Your ref 3/2025/0460  
Our ref DC/25/1777  
Date 26-AUG-25

**Location: Hammond View 38 George Lane Read BB12 7RH**  
**Proposal: Change of use of land from agricultural to residential to extend the domestic curtilage**

proposed site plan

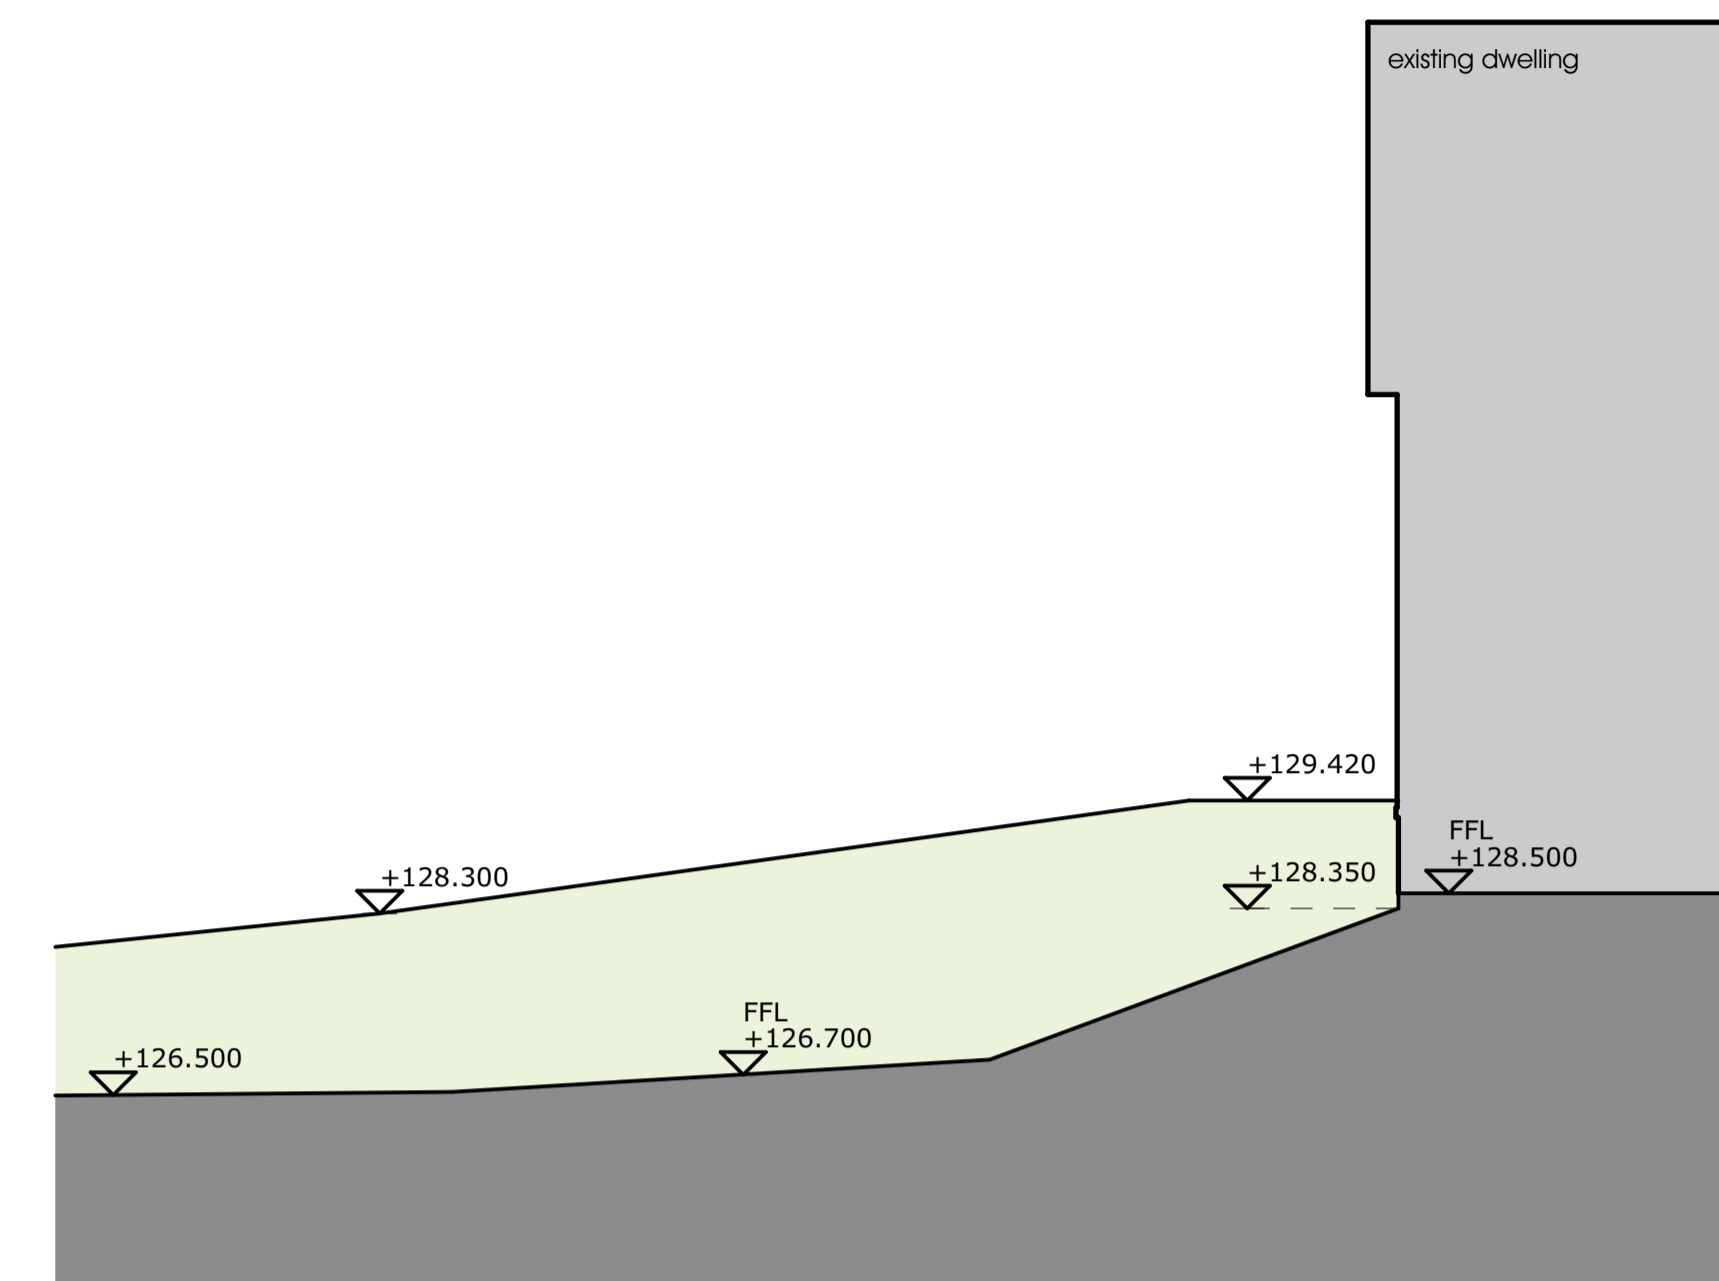
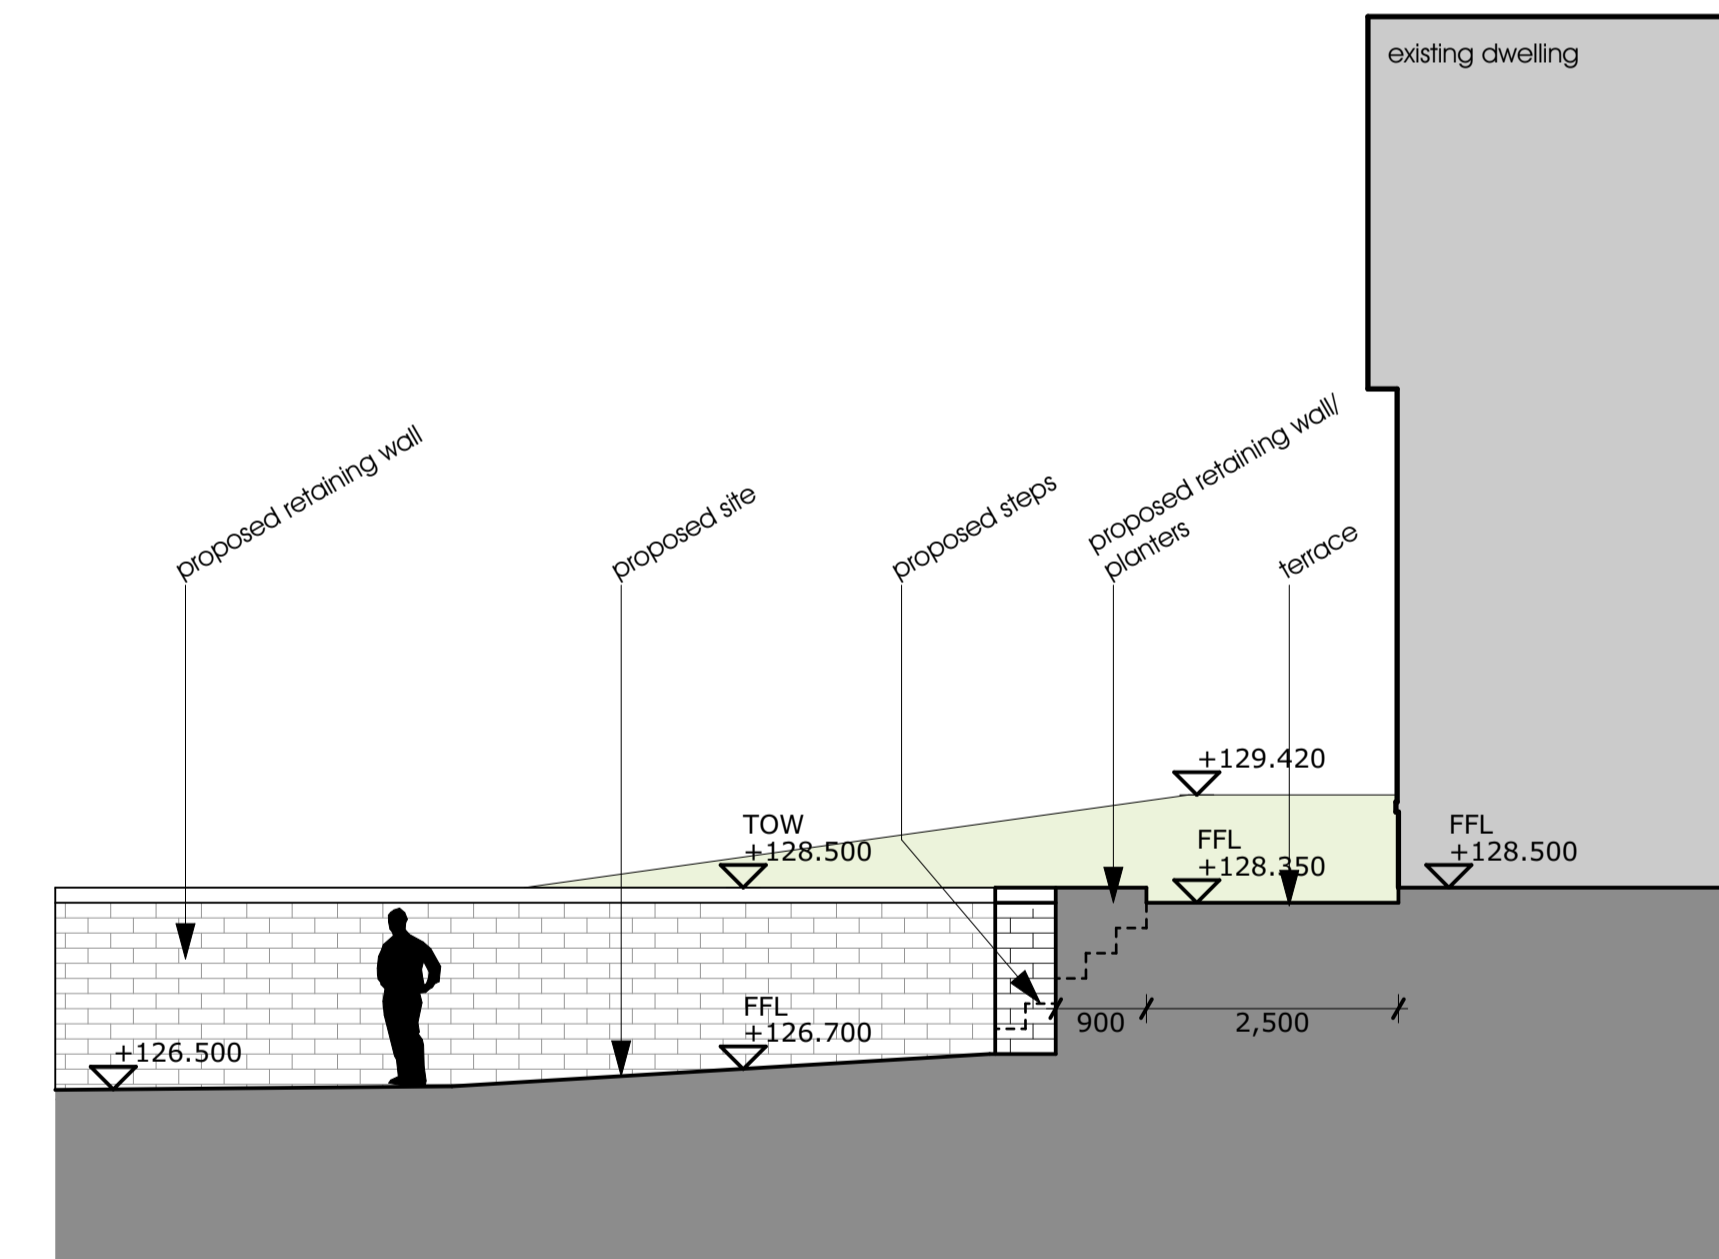
Following our review of the proposed site layout, we can confirm that the proposal is not acceptable to United Utilities as features appear to be located above/in close proximity to our water main. Until such time as the applicant has resolved all concerns regarding the proximity of proposed development to our water assets, **our position is that we OBJECT to the proposal.**

*We note the proposed layout plan shows a diversion to the existing water main; however this may not be acceptable due to its new location underneath the paving.*

To discuss the proposal in relation to the water main we recommend the applicant contacts our Water Developer Services team by email at [DeveloperServicesWater@uuplc.co.uk](mailto:DeveloperServicesWater@uuplc.co.uk). If direct
